Yapton Parish Council
Mr A Gardiner
38 Ruskin Avenue
North Bersted
Bognor Regis
PO22 7ND

Your Ref: OWPC16461
Our Ref: Y/68/17/PL
Please ask for:
Mr R Temple

Alterations & extensions to existing redundant garage building to create 1 No. dwelling & associated works. This application affects the character & appearance of the Main Road/Church Road, Yapton Conservation Area & may affect the setting of a Listed Building.

Garage Premises Main Road Yapton

*proposed northeast elevation*

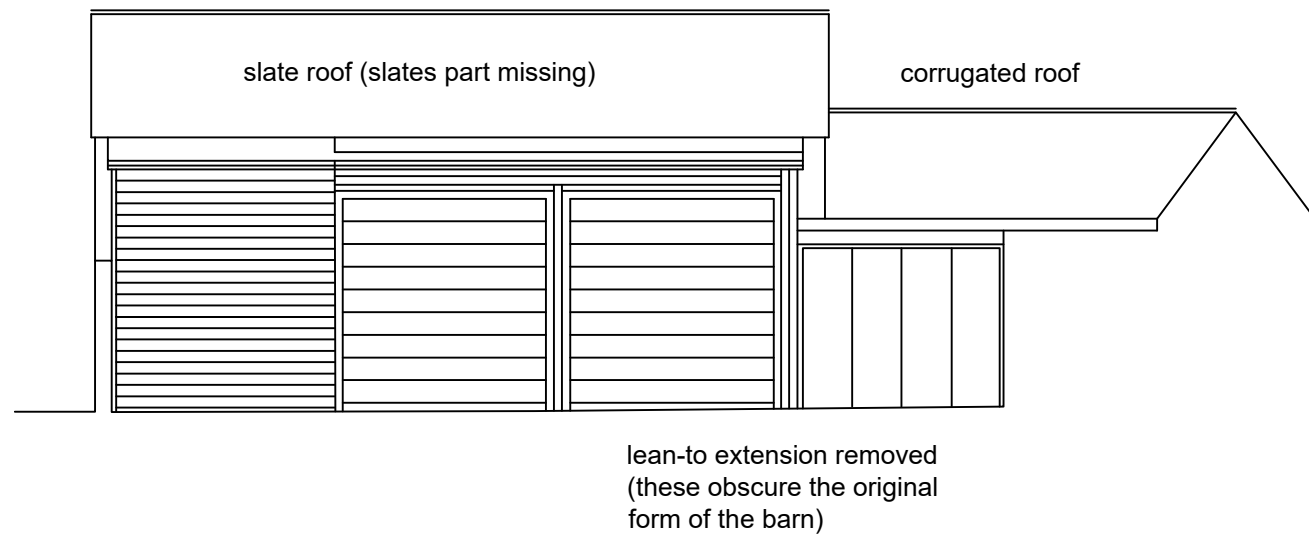
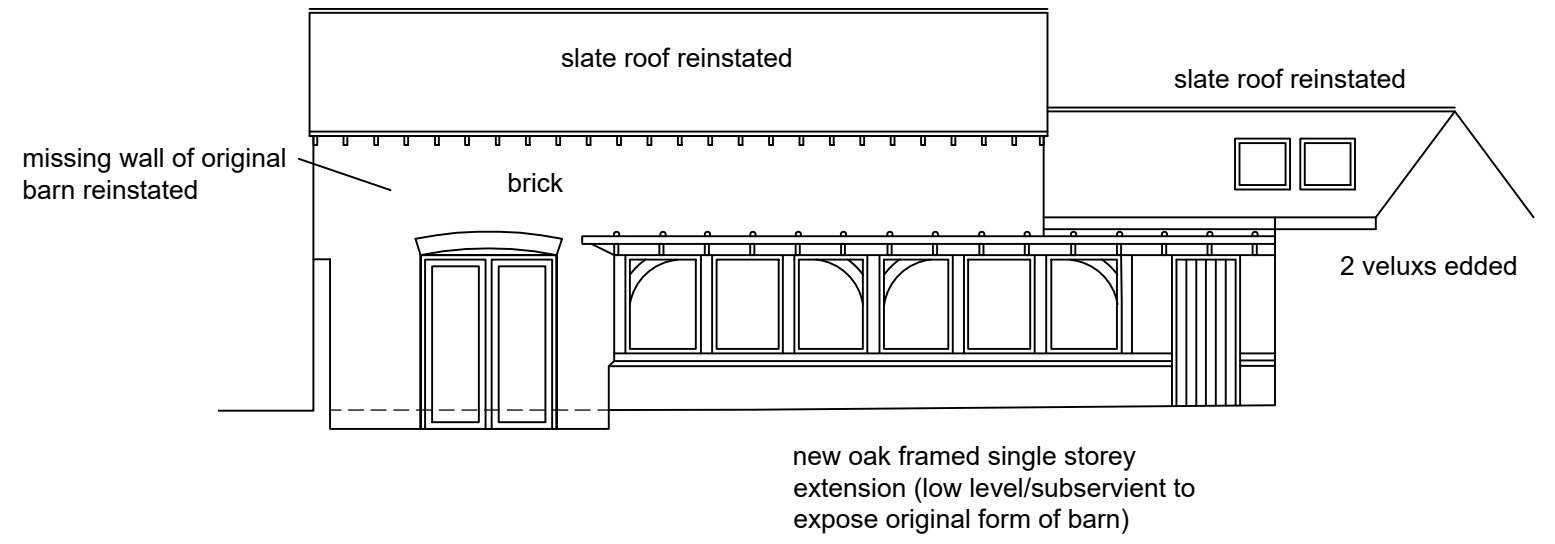
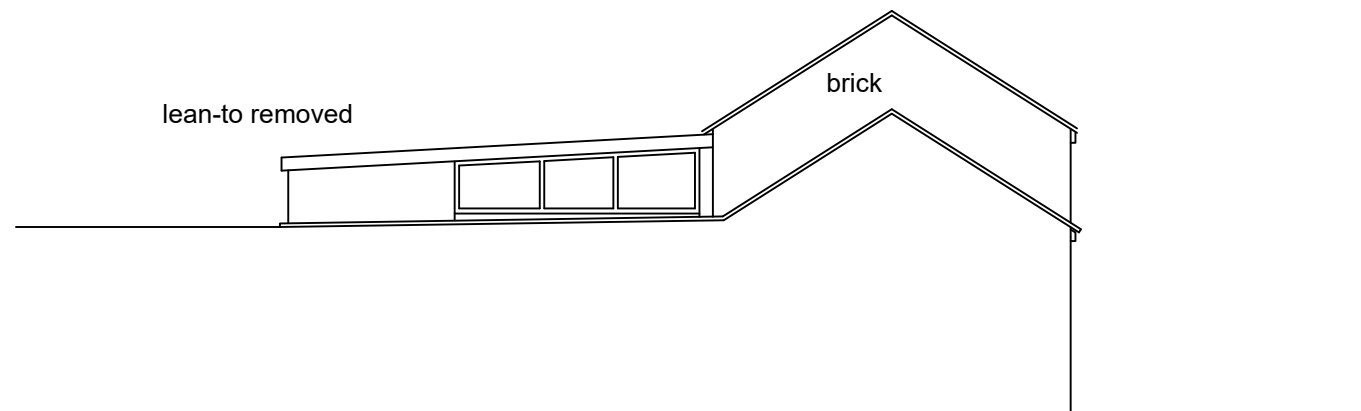
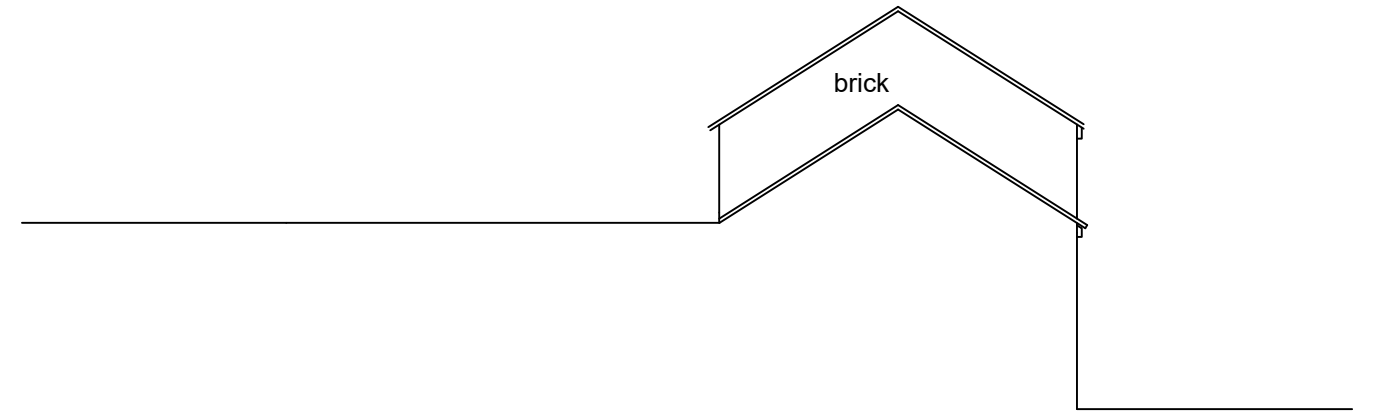
- 1. Environmental survey to ensure no contaminates from the previous garage repair use remain in the soil/ground.*
- 2. Full consideration and use of sympathetic materials for a conservation area in the construction/refurbishment of the dwelling.*
- 3. Conservation style/appropriate fenestration throughout the dwelling.*
- 4. Satisfactory highway solution for access/egress onto Main Road.*
- 5. Roofline not to exceed the existing building's ridge and eaves heights.*
